## REFUSAL OF PLANNING PERMISSION

APPLICATION NO. 2016/1234

**Proposal Raising of roof level to existing garage to create additional accommodation. (Re submission).**

**At** 118 Smithies Lane, Barnsley, S71 1NL

DRAWING
 Existing and proposed details

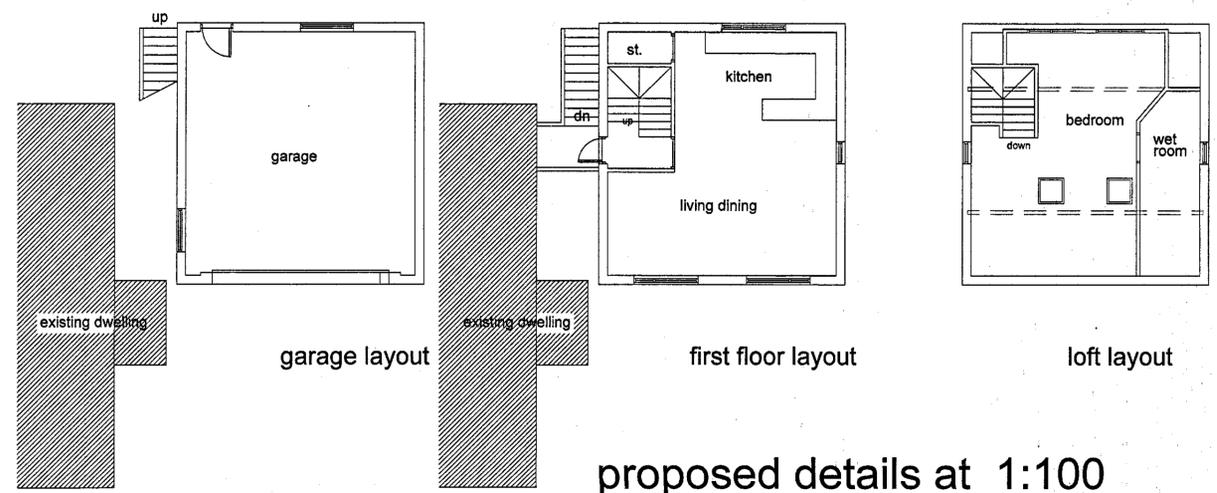
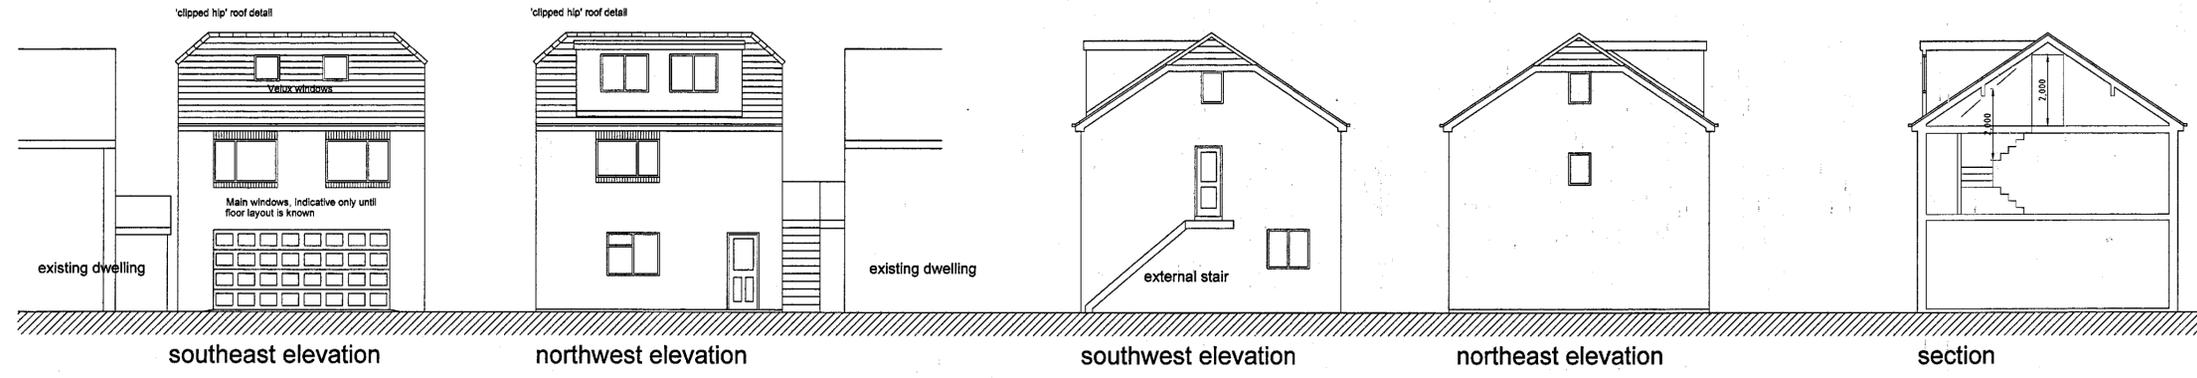
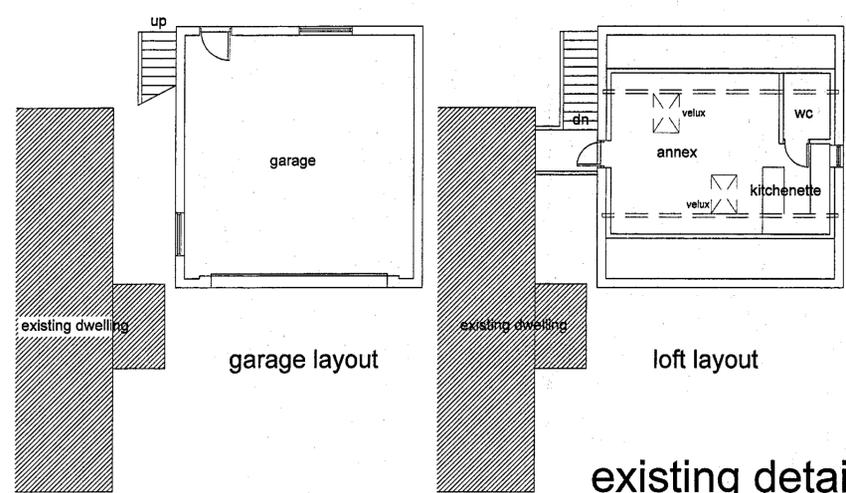
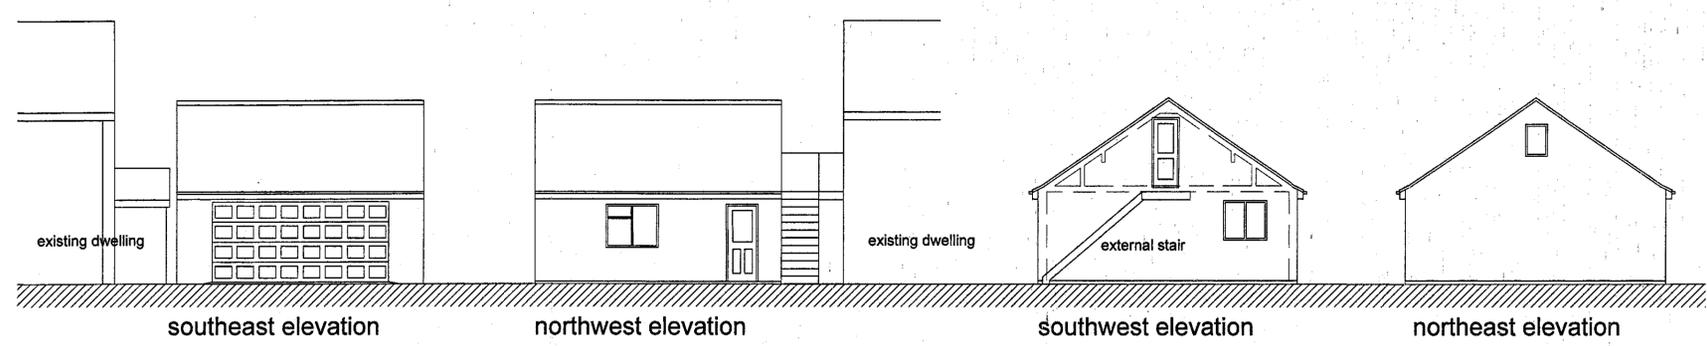
- 1 In the opinion of the Local Planning Authority the scale of the proposed alterations are considered excessive in the context of the host dwelling, the garage as extended would not appear as a subservient feature to the host dwelling, as such it would appear overly prominent to the detriment of the character and setting of the streetscene from which it would be seen. As such the proposals are considered to be contrary to Core Strategy Policy CSP 29 (Design) and the design Guidance contained within supplementary Planning Document - House Extensions.
